My ref: RLS/18/17/AR
Your ref: A/176/17/PL

23rd October 2017

Application for 2 Detached Dwellings.
Land at the 9 Tee, Ham Manor Way, Angmering.

Site Plan (1:200)

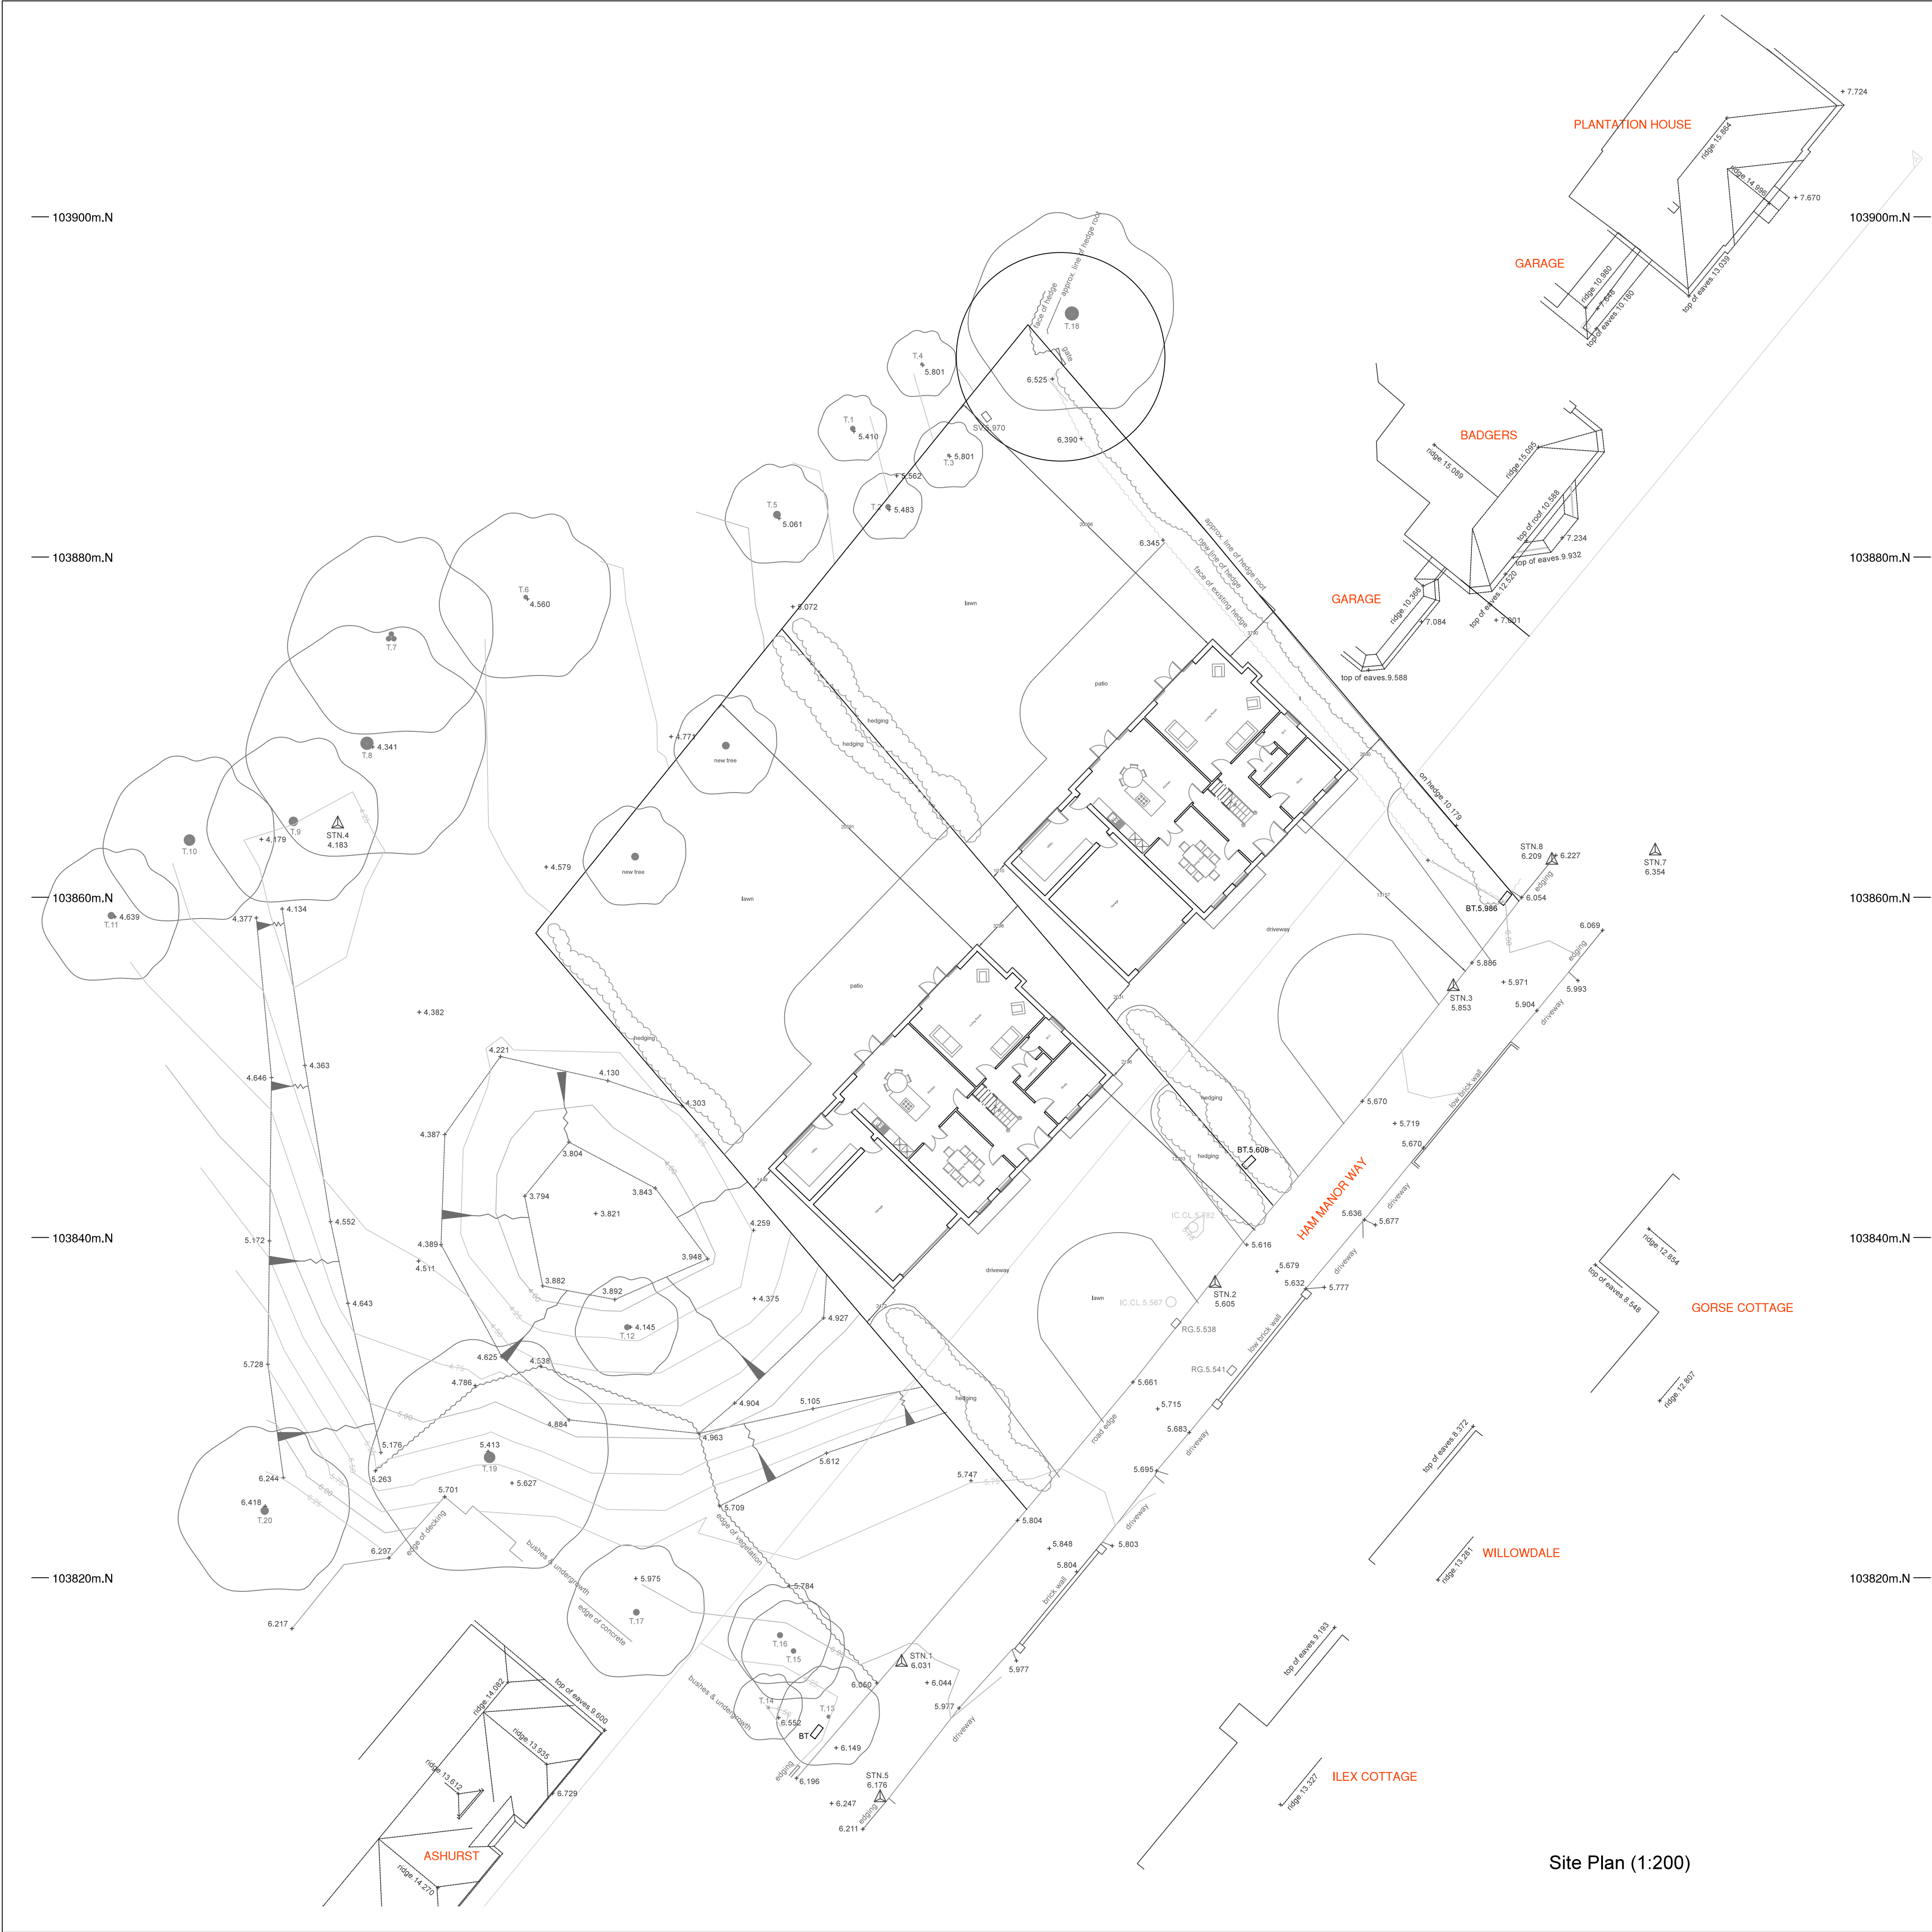
Secondly, the outline permission does not extend to the full plot depth as shown on the application but is significantly shorter, in comparison leaving only approximately 2 metres depth back garden for the unit as now submitted under this application. Accordingly, in the context of the historic outline permissions, notwithstanding that this is now submitted as a full application, they cannot now be relied upon by the applicant in endorsing his current application.

If in the alternative your Council is minded to approve the application on the middle plot consistent with the granting of the two outline planning permissions the depth of the plots will have to be reduced consistent thereto. This may also raise another matter if the unit is to be moved forward as this will clearly affect the ability of the site to provide the level of on-site car parking currently provided. Finally, it also needs to address and resolve the surface water drainage both over this site and also in respect of the adjoining highway where clearly water disperses from the highway onto and through these two plots as water passes to a low point on the Course to help minimise the totality of that effect.

The last matter I would raise with you now is that in the e-mail to you this site is described as "plot 7, 8 and 9" from the historic permissions. In looking at the details submitted from those permissions I would maintain it is just plots 8 and 9 and repeat again that these are of smaller depth at the southern end of this site with the northern element shown not to be included within those permissions retained as an open area.

Street Elevation (1:200)

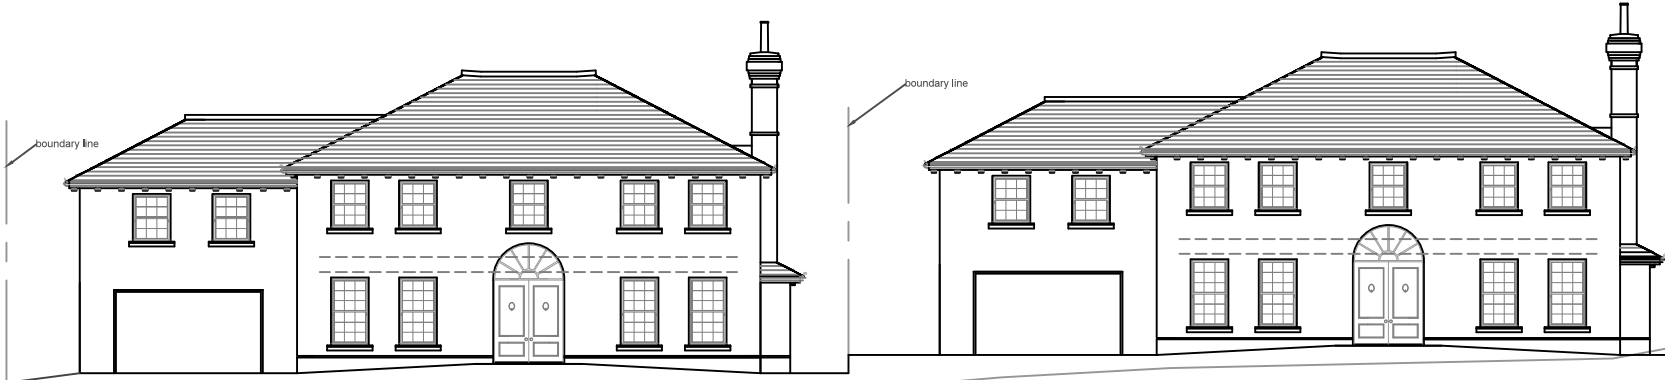
Finally, of course there is the impact of replacing the open concept and views across the golf course with the introduction of two full width dwellings which will significantly impact by reducing the open outlook currently available, especially, on the outlook enjoyed by residents living opposite the development. It is also worth noting that the overall width of the units is significantly wider than many in the area, with less sense of space either side. Sadly this is further emphasised by the lack of planting to soften their appearance, with the result being that these units now appear wholly out of character in this location. The width of the site is clearly vitally important in context and much smaller dwellings on similar plots are required here to ensure that your Councils Planning Policies are satisfied.
